COMPLETED 10/26/06 stt  
DRB CASE ACTION LOG (FINAL PLAT)  
REVISED 9/28/05

DRB Application No.: 05DRB-00294 (FP)

Project # 1003759

Project Name: LANDS OF KEN BALIZER

**PLAT OF
TRACTS 1, 2 & 3
LANDS OF KEN BALIZER**
WITHIN SECTION 6, T. 10 N., R. 3 E., N.M.P.M.
CITY OF ALBUQUERQUE
BERNALILLO COUNTY, NEW MEXICO
OCTOBER 2006
SHEET 2 OF 2

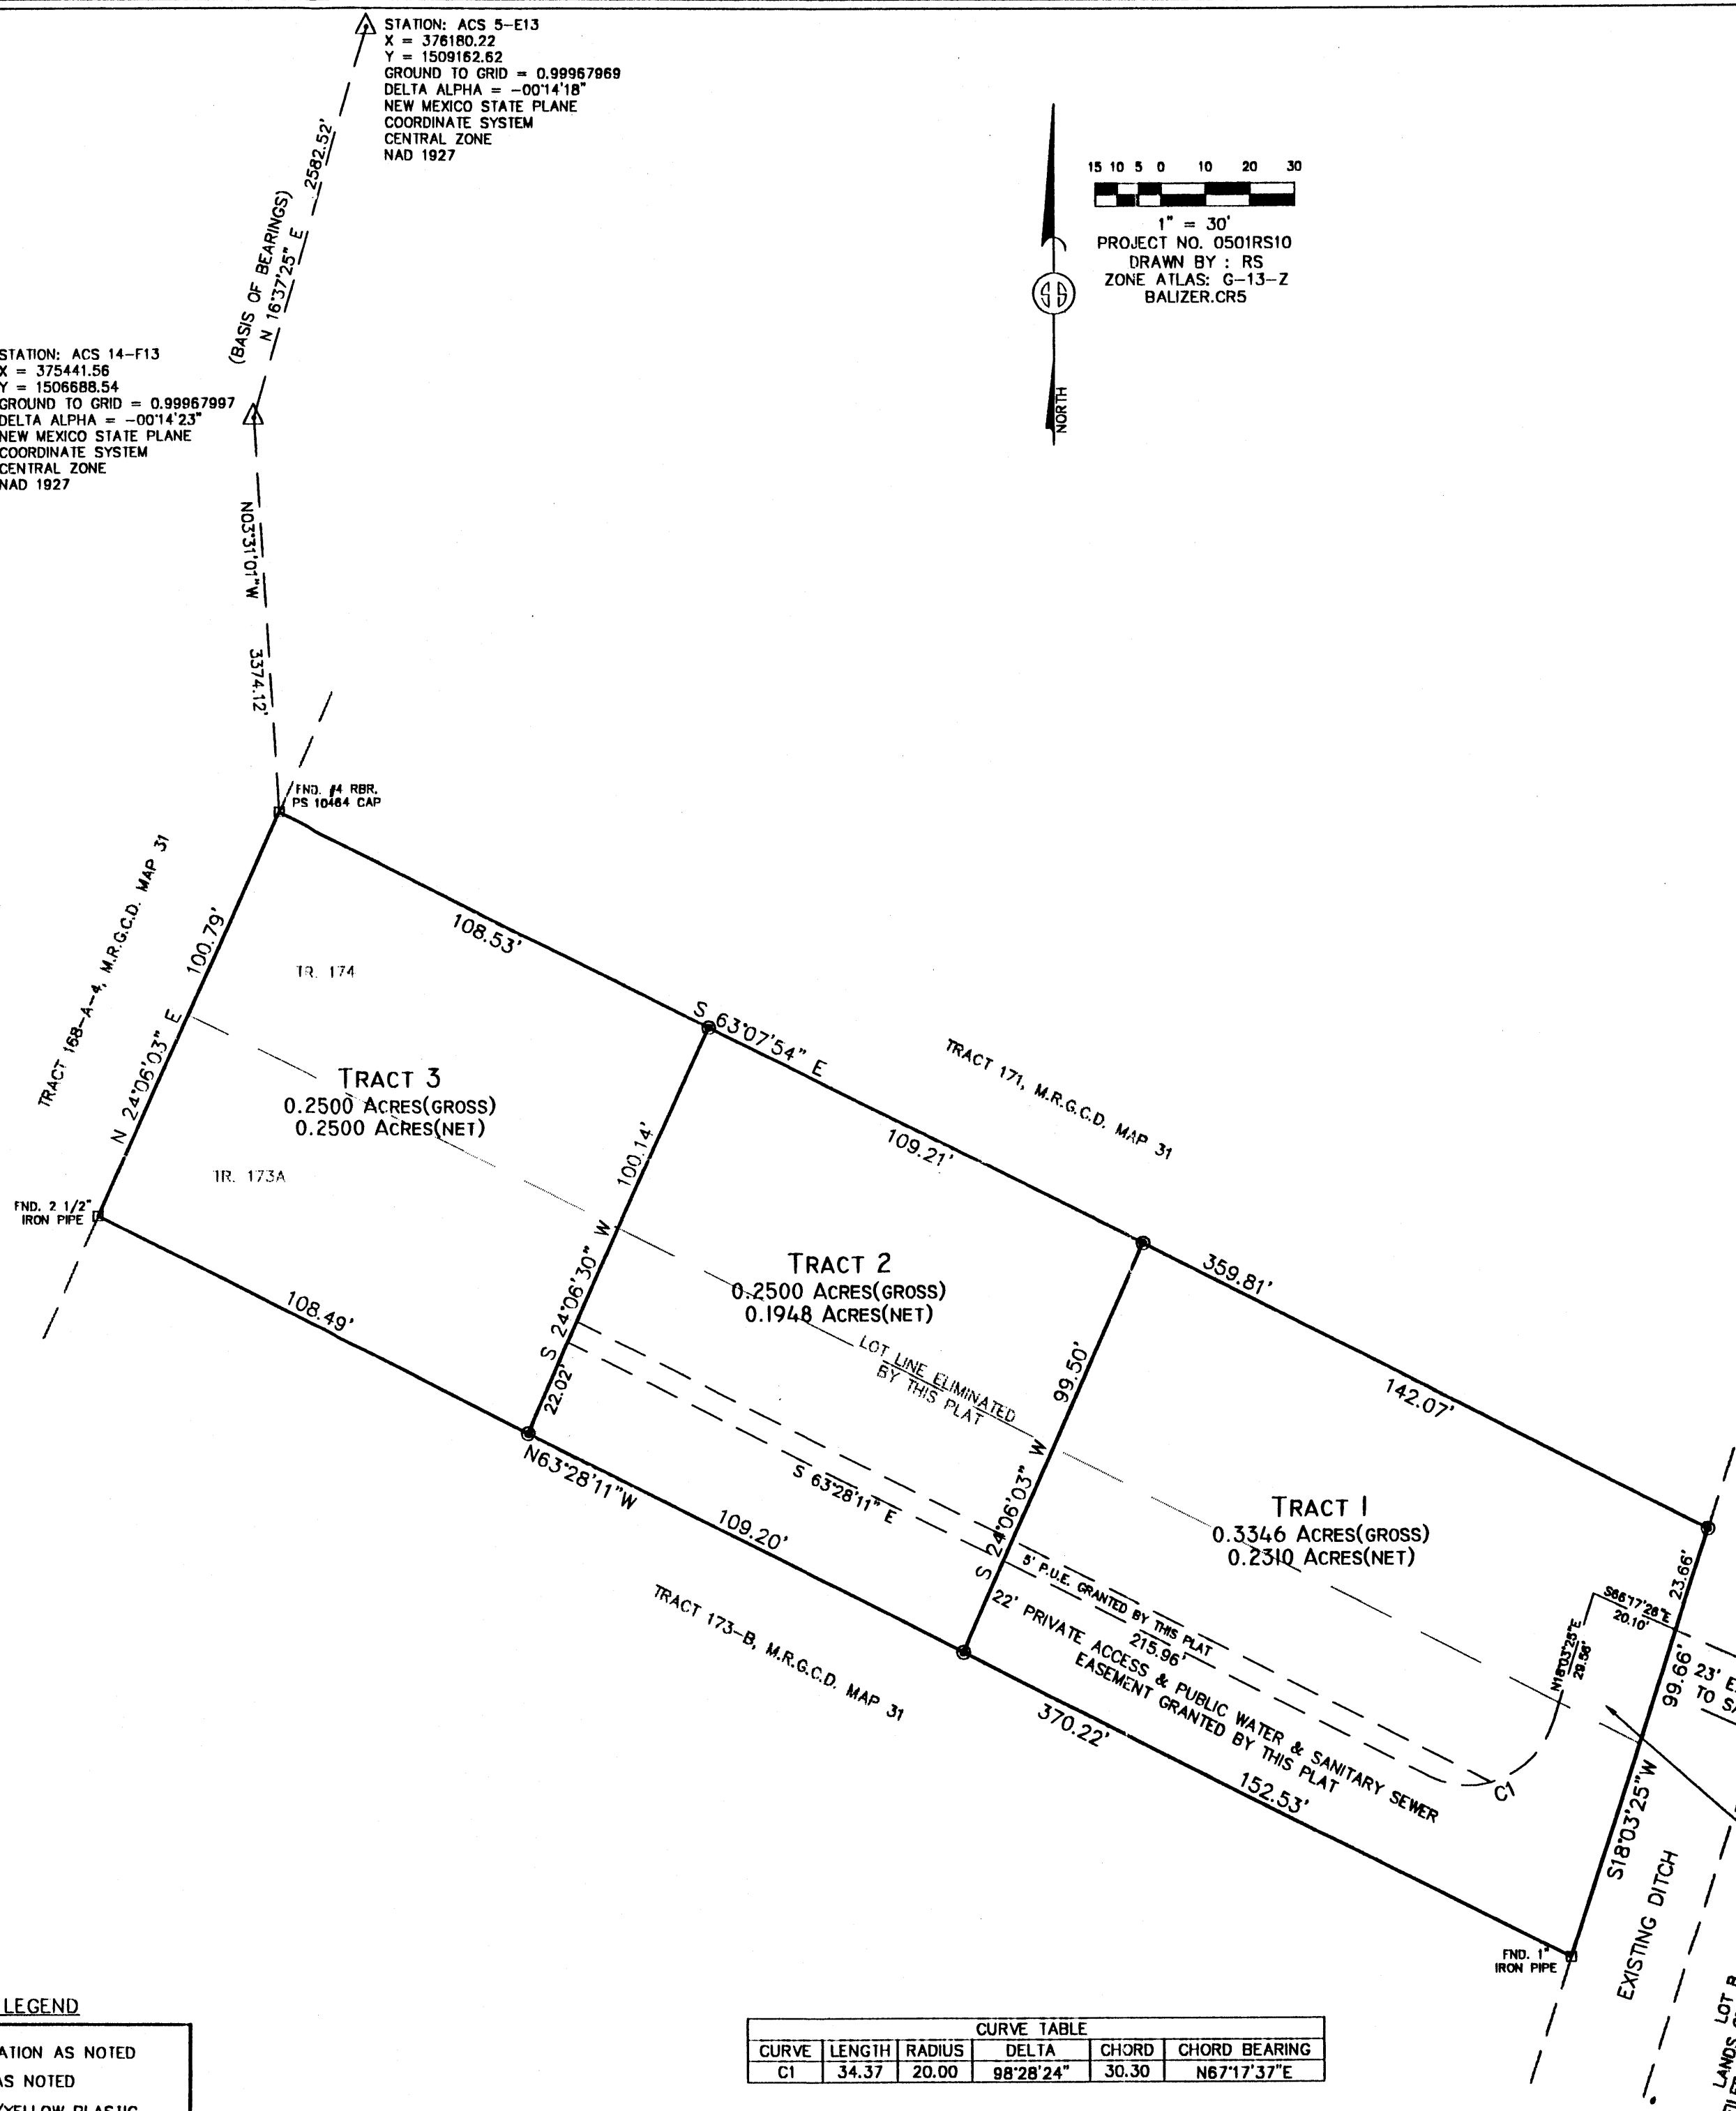
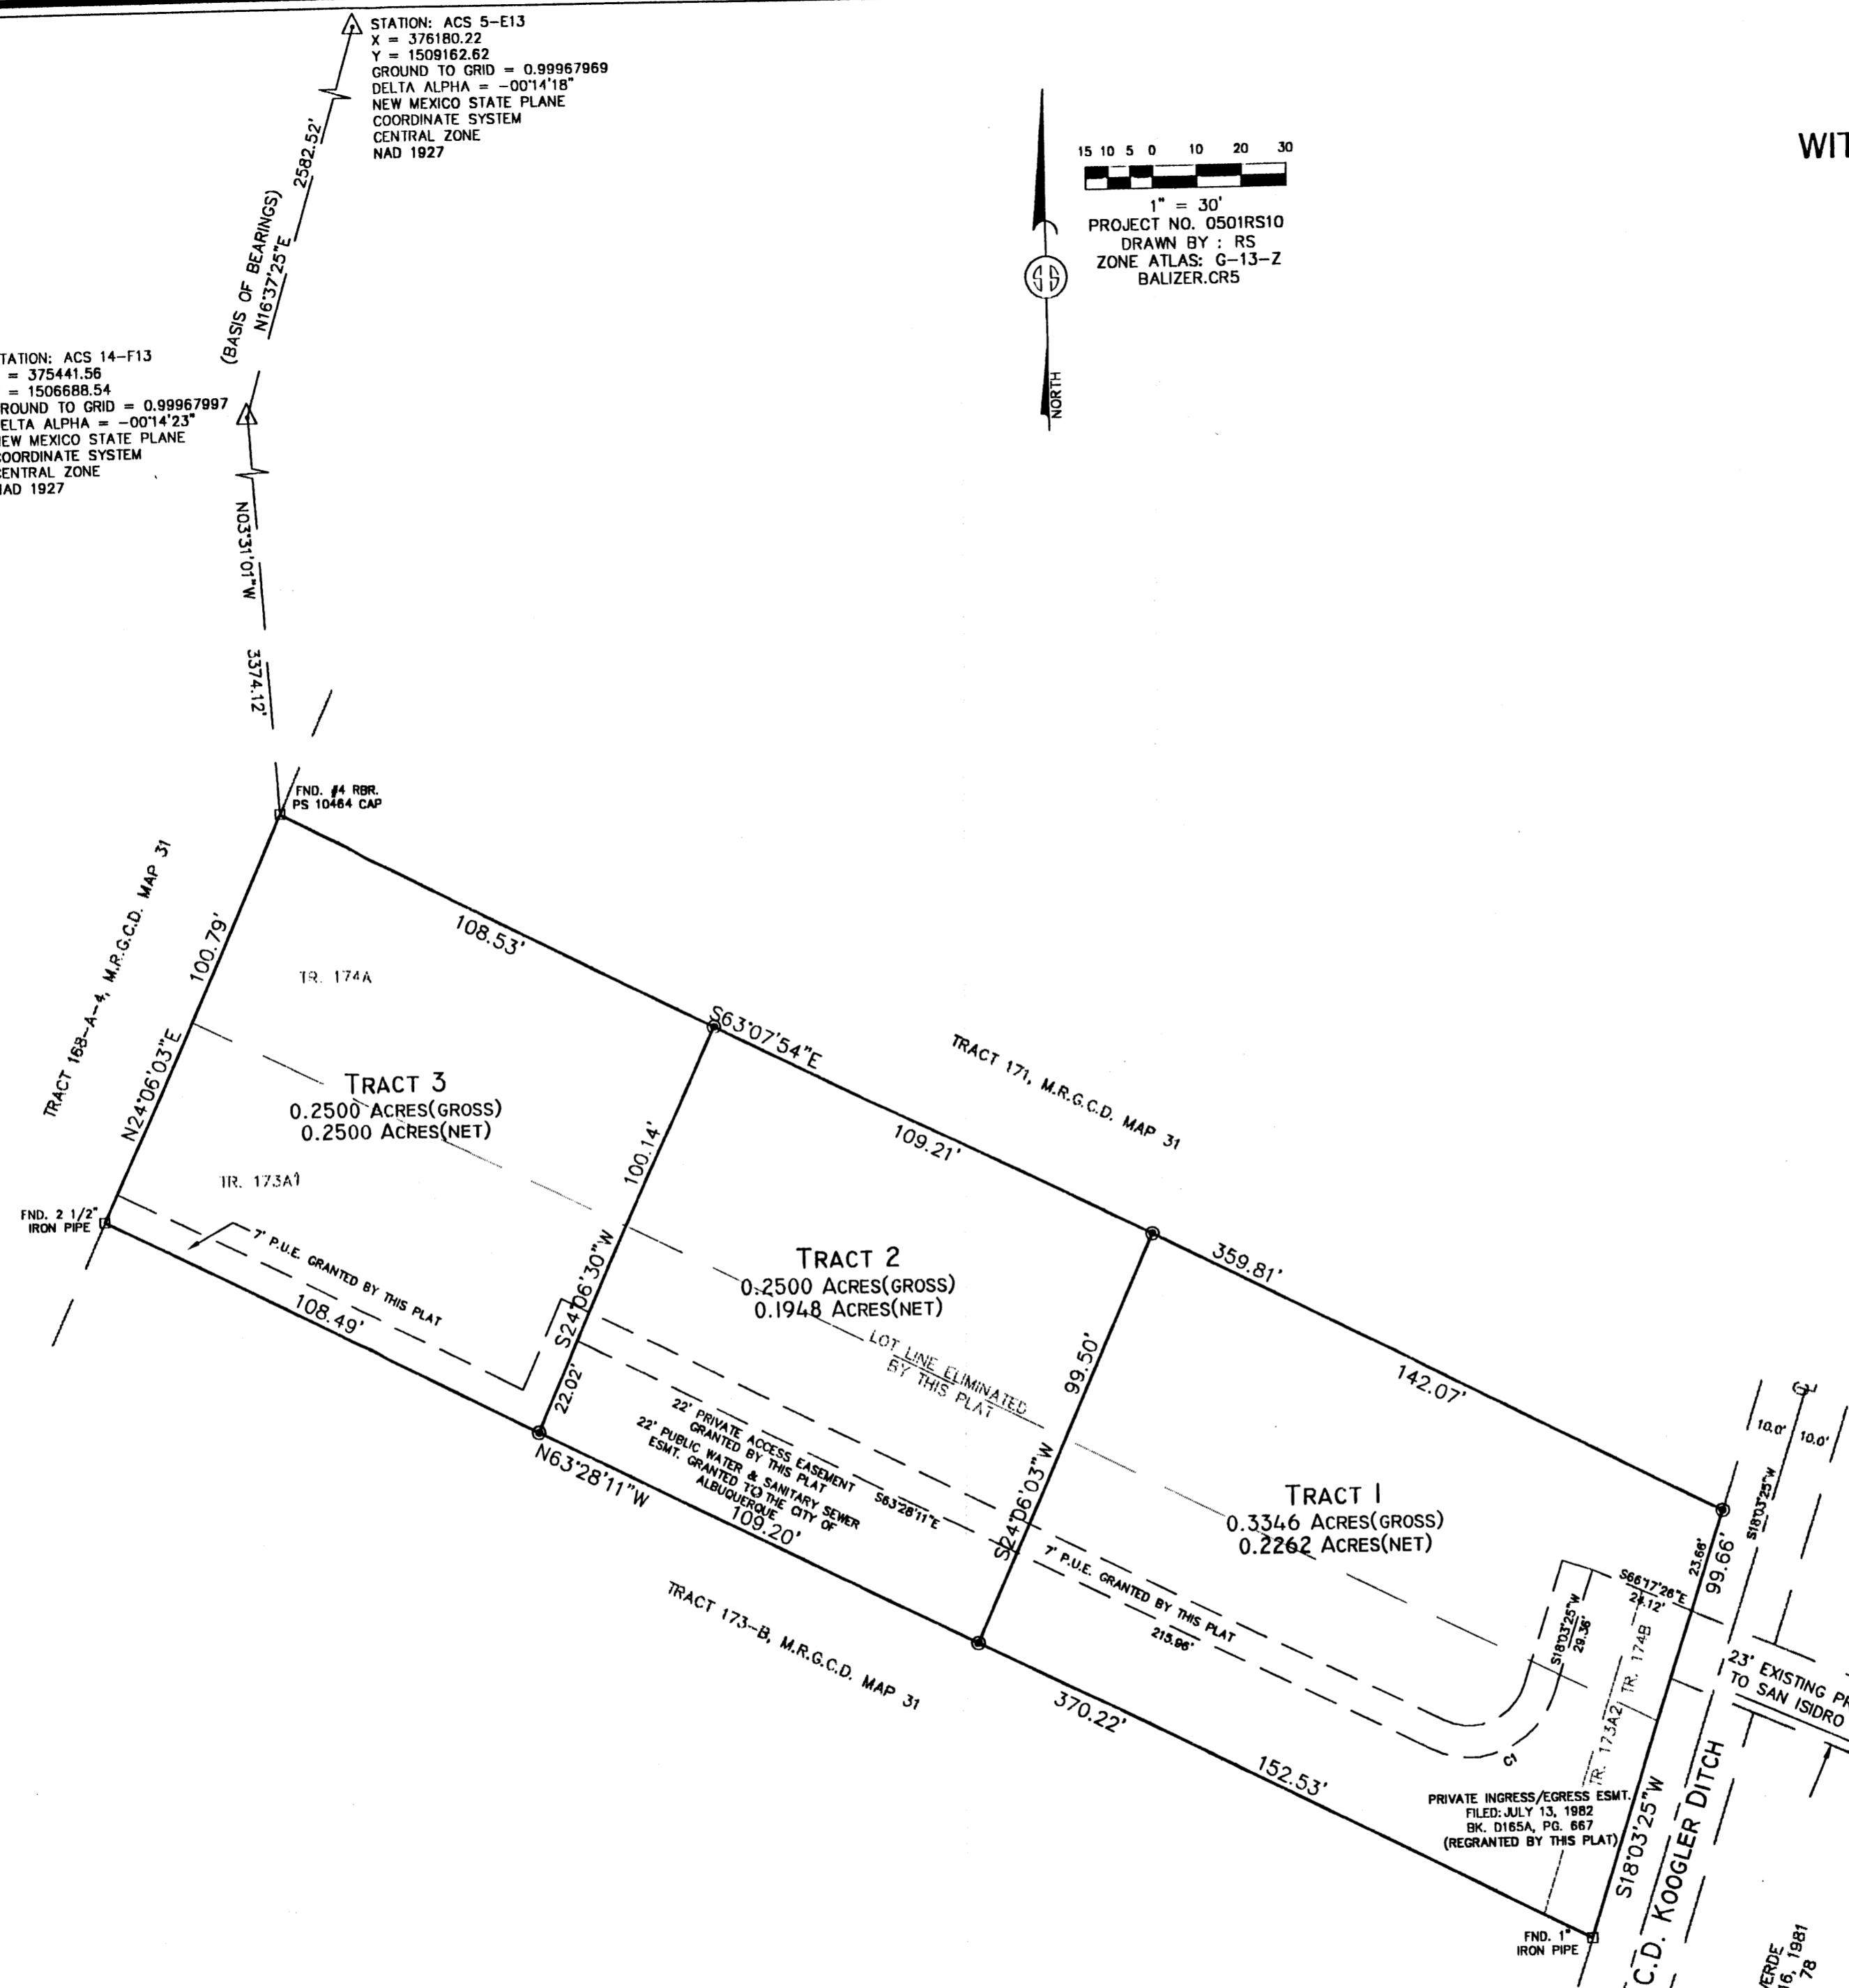
- CITY ENGINEER / AMAFCA: \_\_\_\_\_
- MRG CD signature
- City esmt (SDS to WF)
- Correct call out of road esmt. **3ok**

MRGCD must sign plat prior to City Engineer signoff.
